2 August 2013

**Planning Application Reference Number – 3/2013/0613**

**Outline Application 9 Dwellings**  
**Land to Rear of Highfield, Garstang Road, Chipping**  
**Security and Crime Analysis**

| Drawing No. | Date | Scale | Drawn By |
|--------------|--------|-------|-----------|
| CD/JMP/35025 | Feb 13 | 1:100 | Julia Pye |

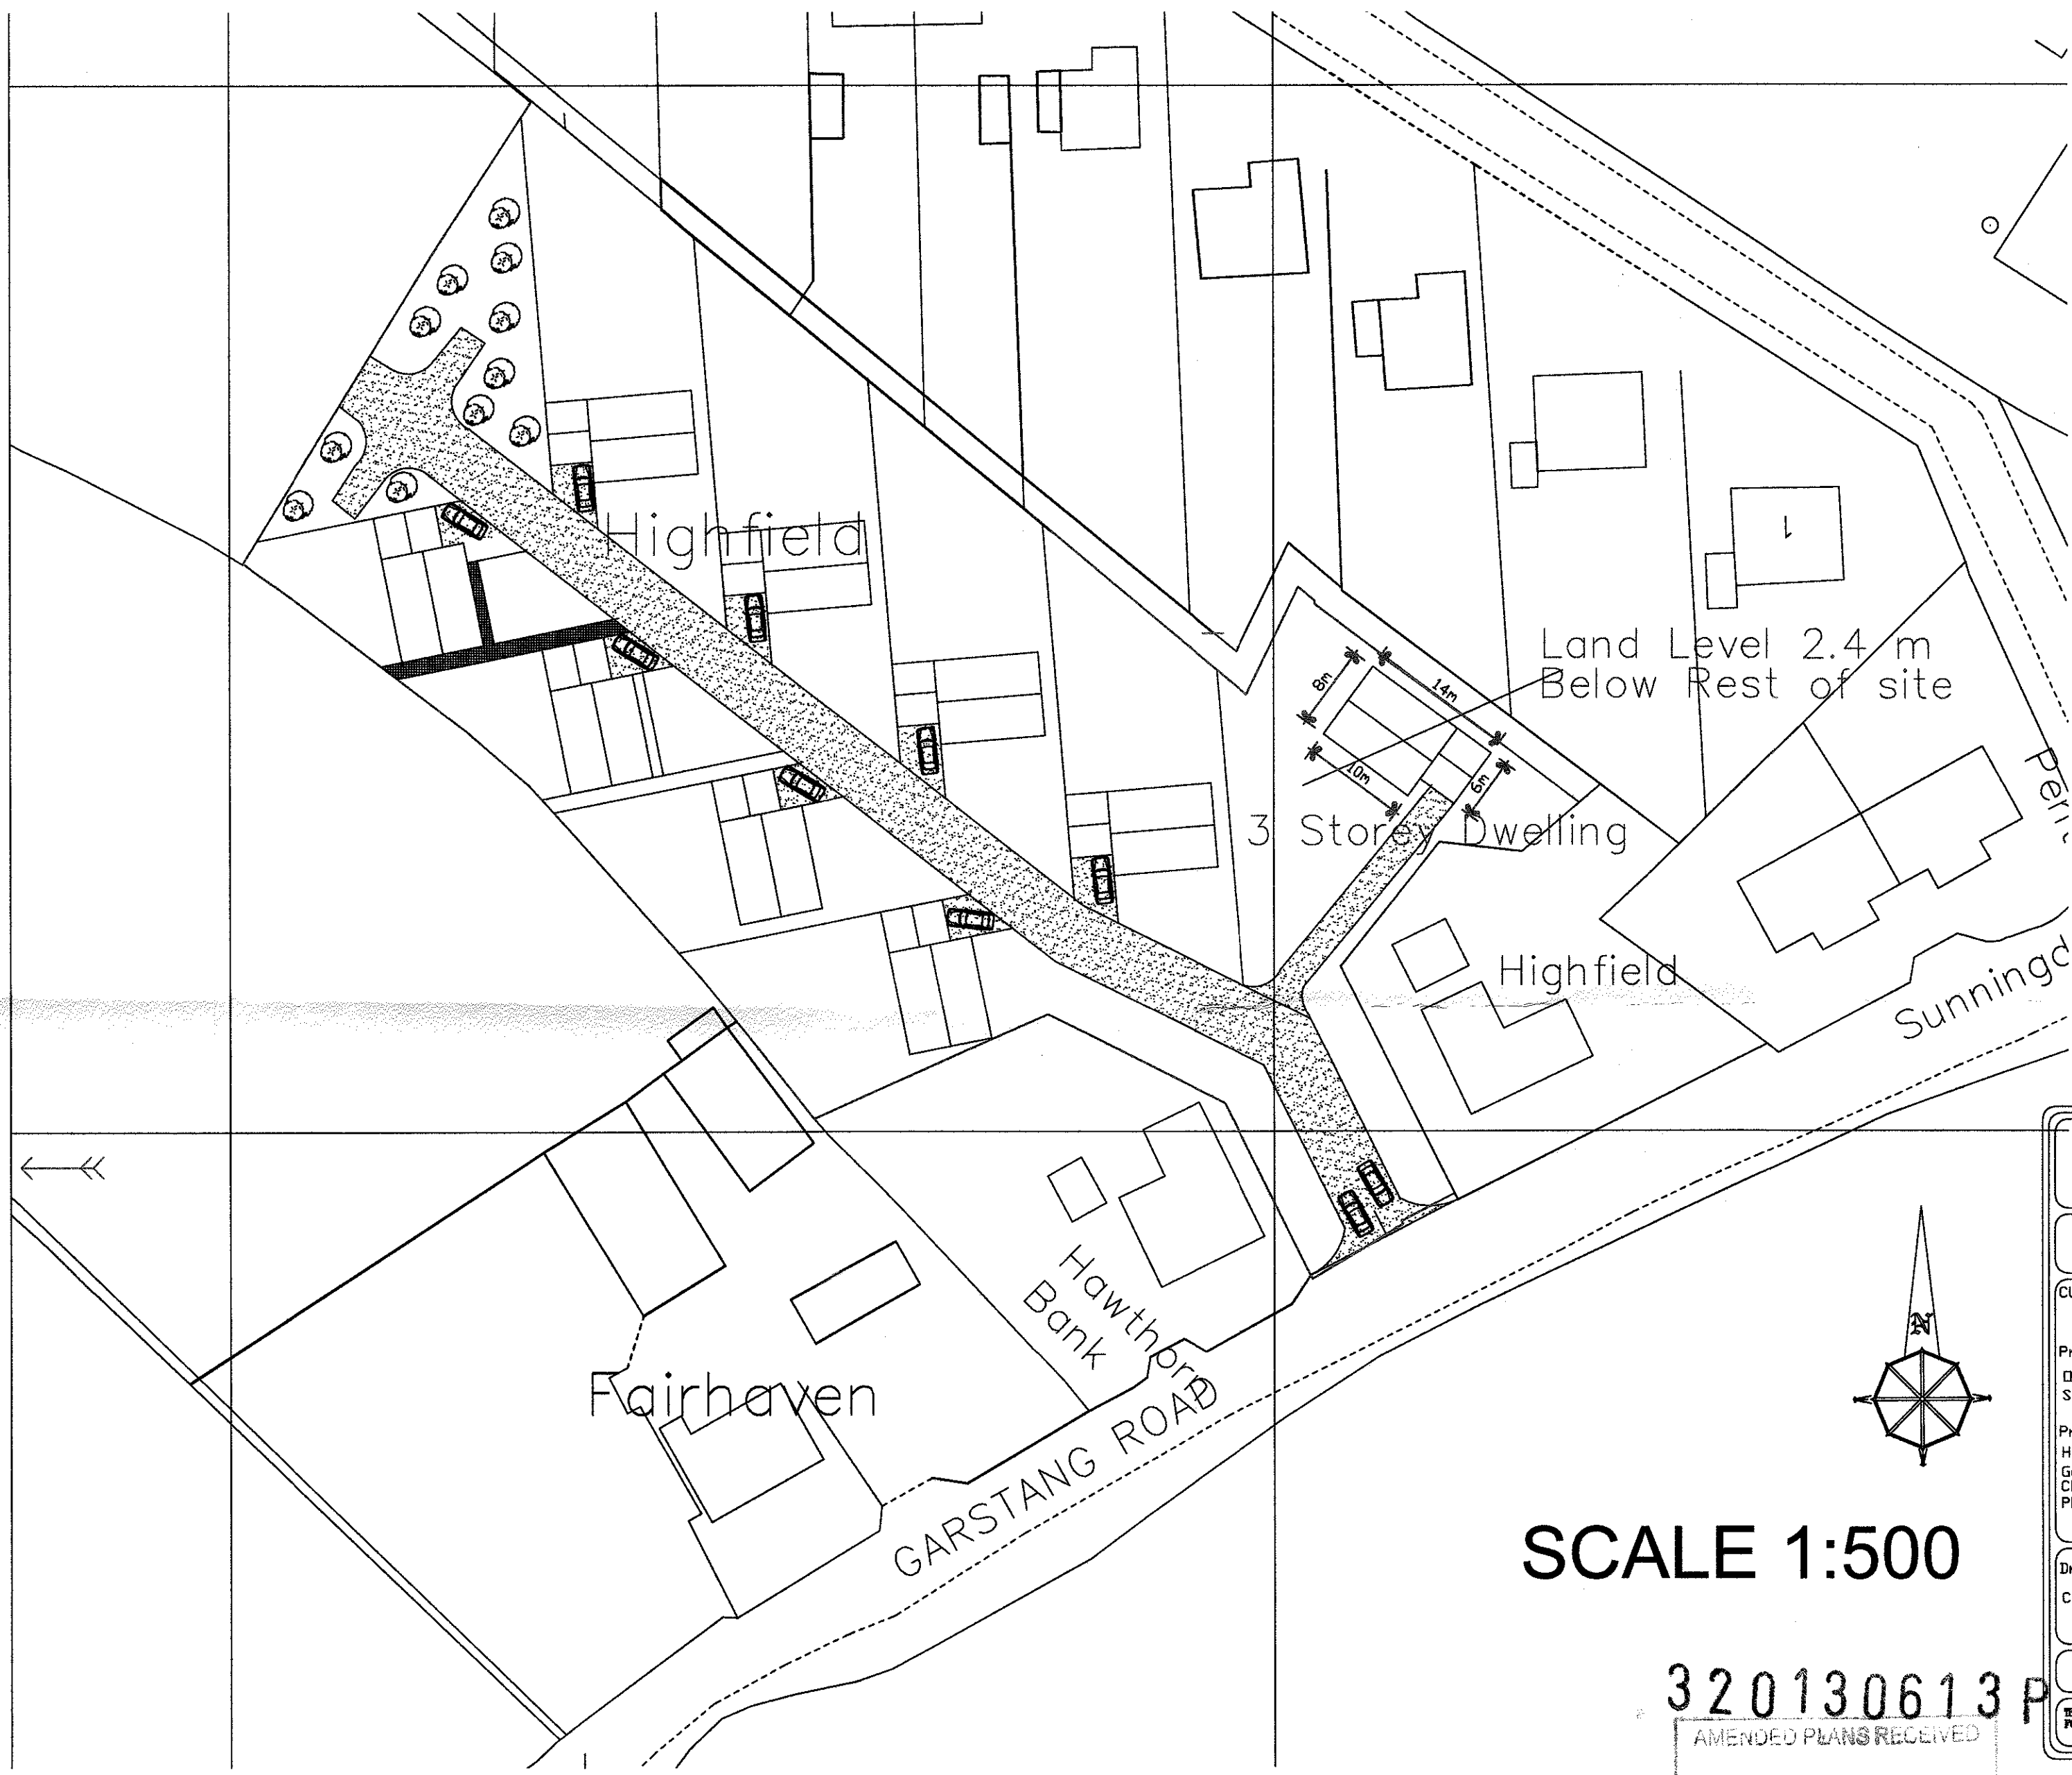
- Each of the proposed plots sits in large grounds. I recommend that the boundaries of the properties are secured with a 1.8m fencing arrangement such as close boarded or similar to prevent unauthorised access to the vulnerable rear of the properties. A 1.5m arrangement with a trellis topping up to 1.8m provides a secure enclosure whilst creating the opportunity for natural surveillance. It is important to secure the boundary of the properties as they are afforded minimal natural surveillance at the rear as they border large gardens of adjoining properties or green open space.

- Access to the side and rear of the dwellings should be secured with a 1.8m lockable gating arrangement to prevent unauthorised access.
- The Design and Access Statement indicates that the appearance of the dwellings will be addressed under reserved matters. I recommend at this

- Units should be fitted with a dusk till dawn lighting unit at the front and rear and garages should be secured with a PIR Security light.
